DRB Application No.: 04DRB-00053 (P&F)	Project # 1003085
Project Name: Lands of Carruthers	EPC Application No.:
Agent: Surveys Southwest	Phone No.: 9980909

**CITY OF ALBUQUERQUE
PLANNING DEPARTMENT
Development Review Board
January 28, 2004
Comments**

RE: Lot B, Lands of Carruthers/minor plat

**SITE PLAN** 1/8" = 1'-0" 3 PATIO HOUSES  
 1804, A, B & C OLD TOWN RD NW  
 LOT B, LANDS OF CARRUTHERS MAP J-18-Z  
 GEORGE L. CARRUTHERS 245-8662 7-26-03

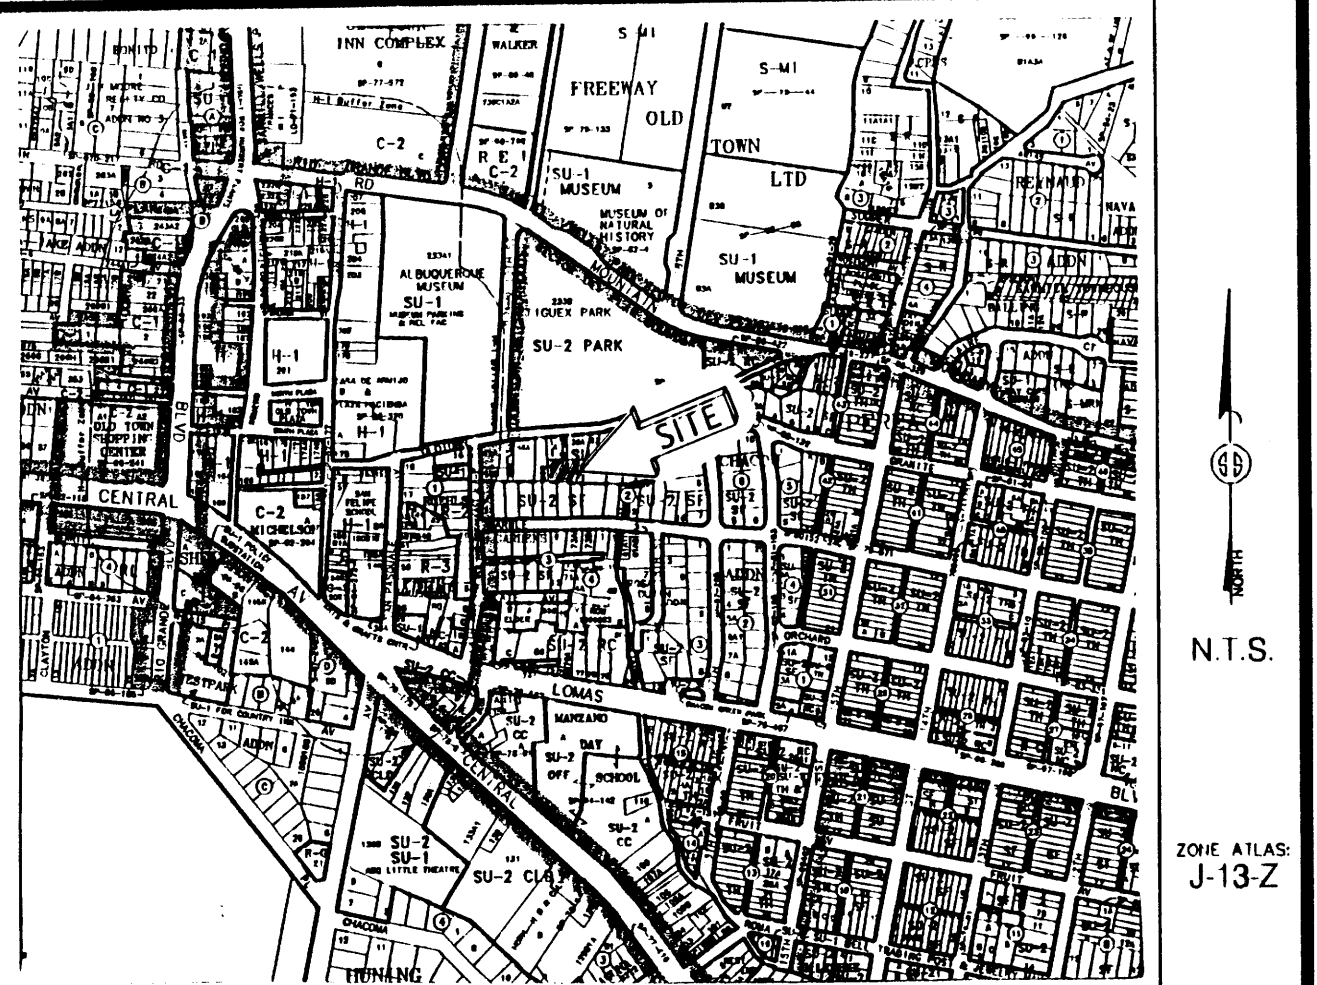
No.	Comment
①	LOW EASEMENT REQ'D ACROSS LOT B-1 NEED 25' RADIUS @ CORNER
②	FIRE / SOLID WASTE REVIEW & APPROVAL?

LOT LETTERED B PLAT OF LOTS A AND B LANDS OF CARRUTHERS SITUATE WITHIN SEC. 18, T. 10 N., R. 3 E. N.M.P.M. AS THE SAME IS SHOWN AND DESIGNATED ON SAID PLAT THEREOF FILED IN THE OFFICE OF THE COUNTY CLERK OF BERNALILLO COUNTY, NEW MEXICO ON JUNE 29, 1999 IN BOOK 99C, PAGE 165.

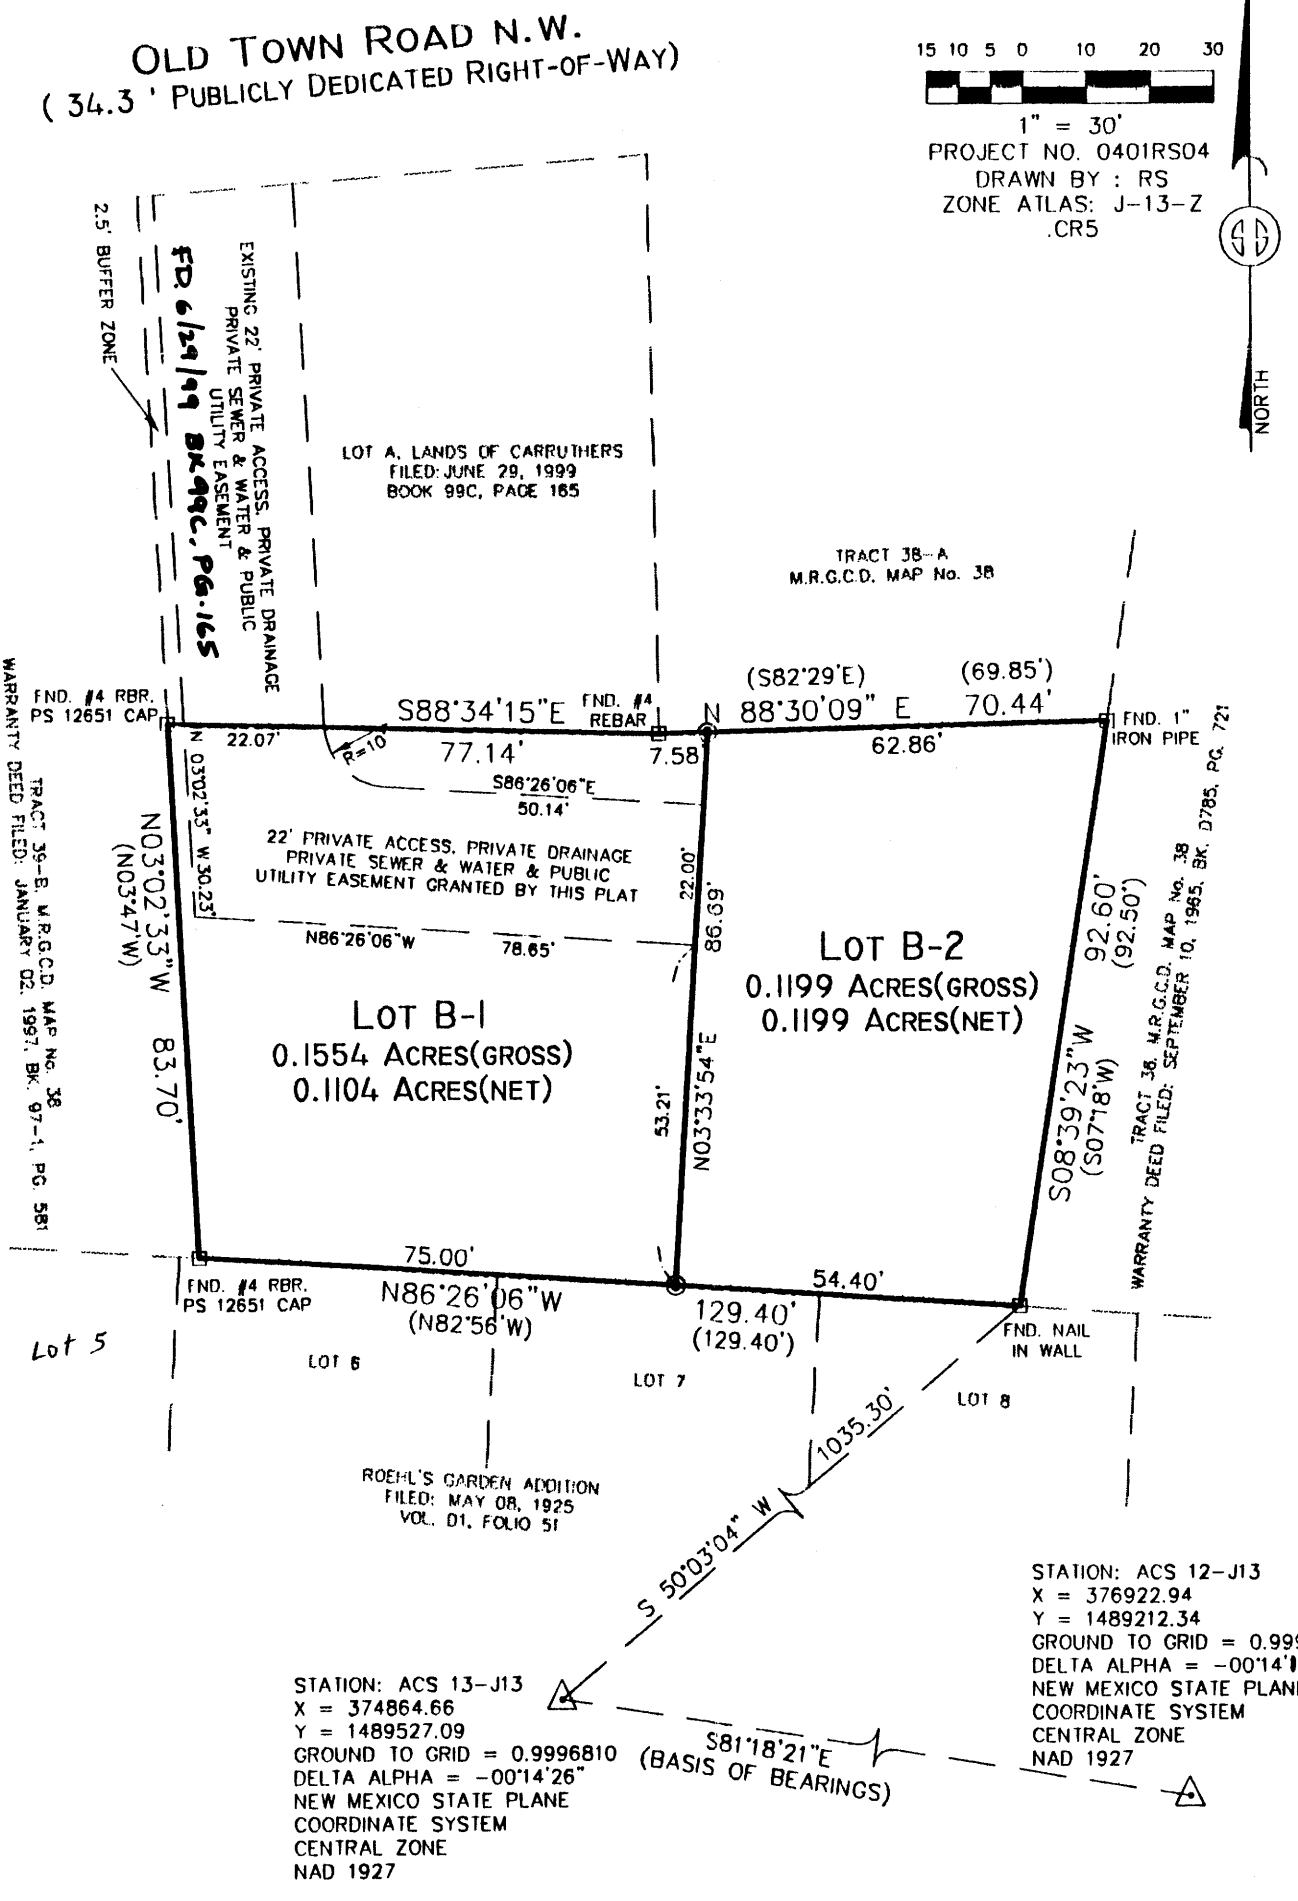
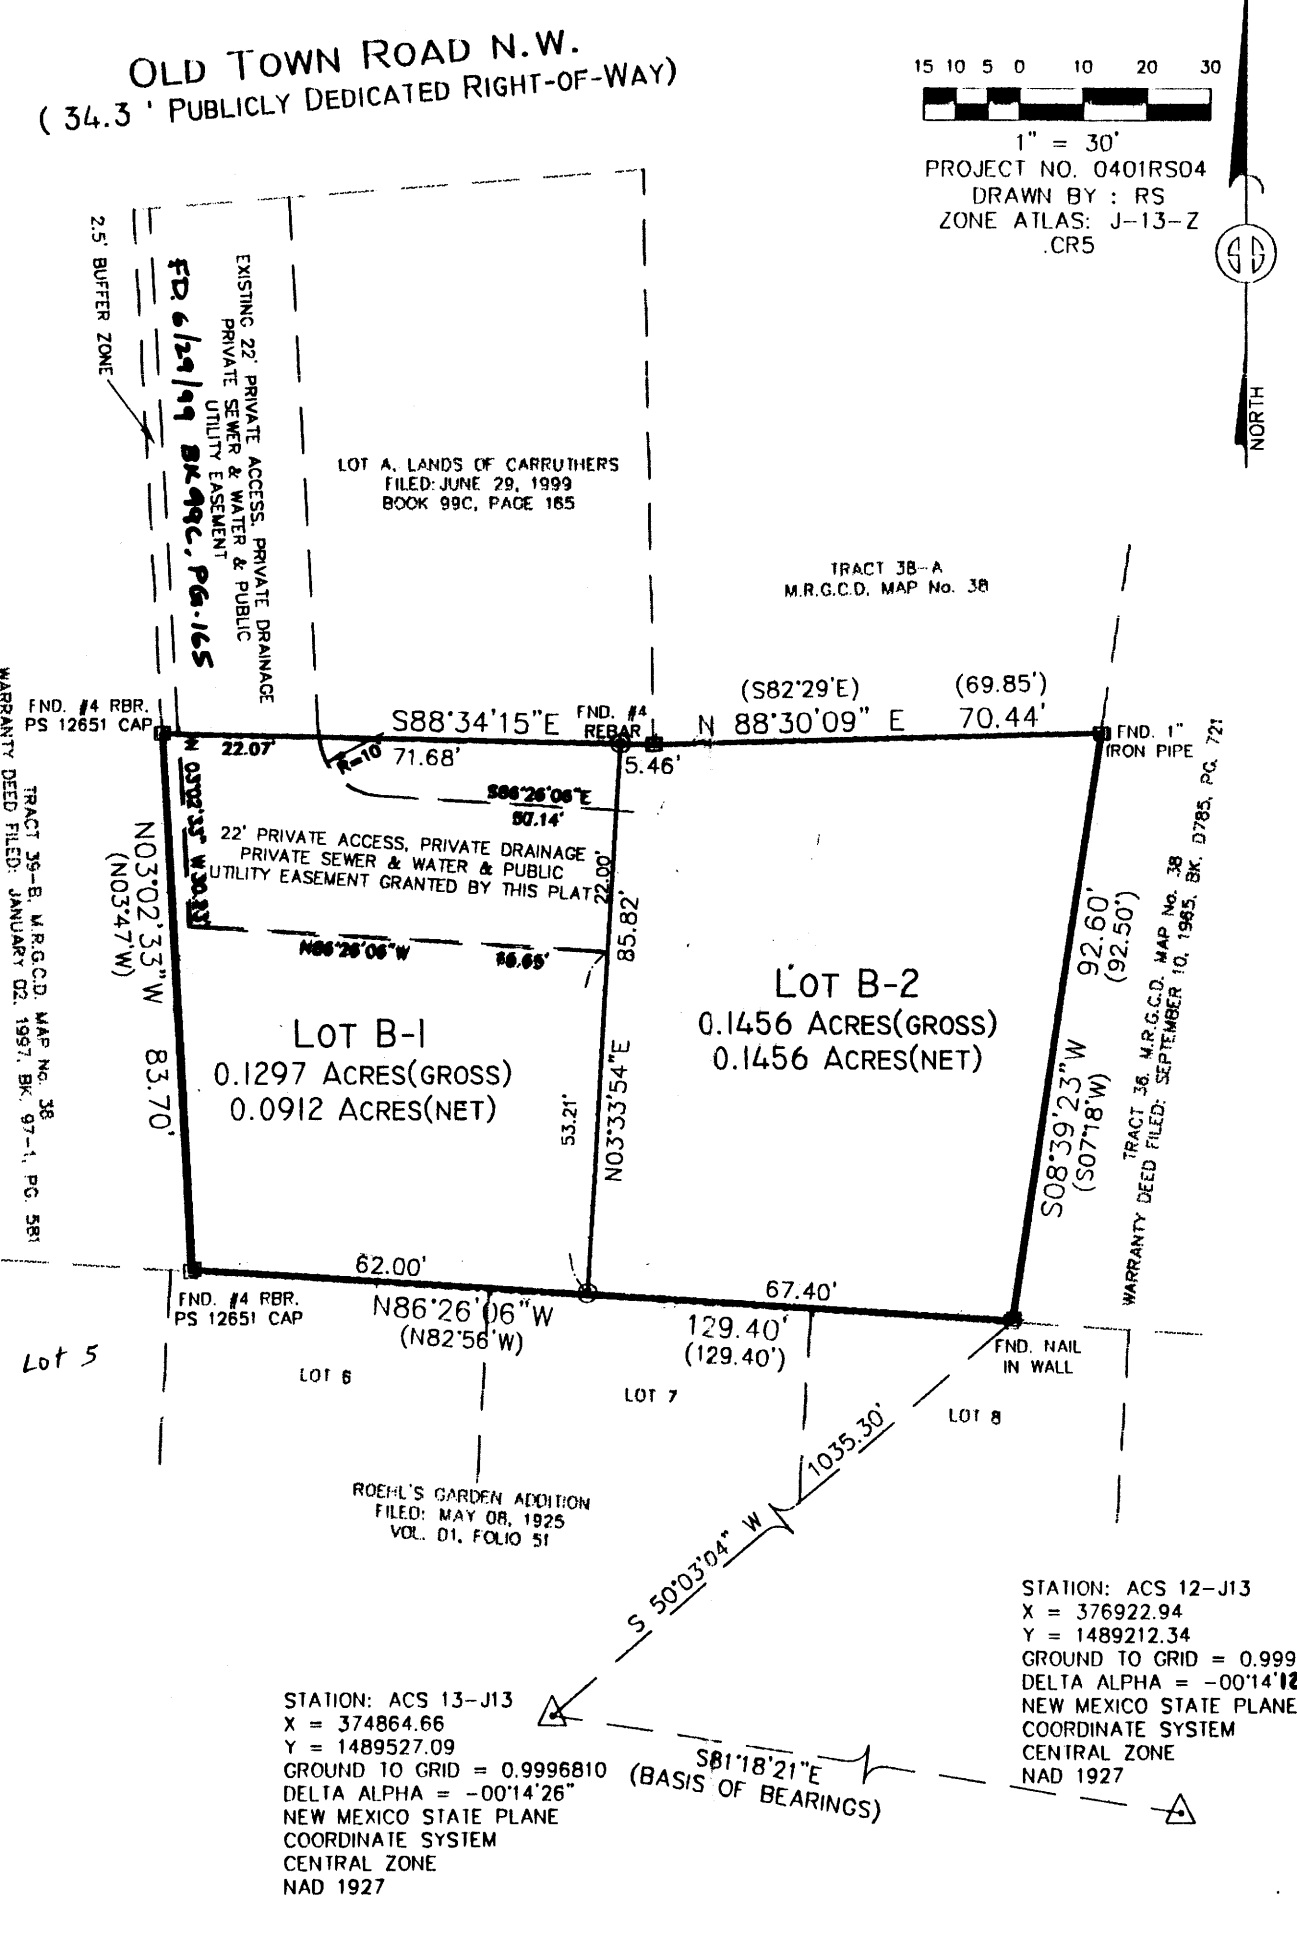
① IF Proposed Lot B-1 is to have 2 residential units and Lot B-2 is to have 1 unit, then a public water & sewer line needs to be extended to Lot B-1 across Lot A in a public easement.

② if each lot only needs a single water meter/sewer service for each lot then meters can be at street and no public line extensions will be required.
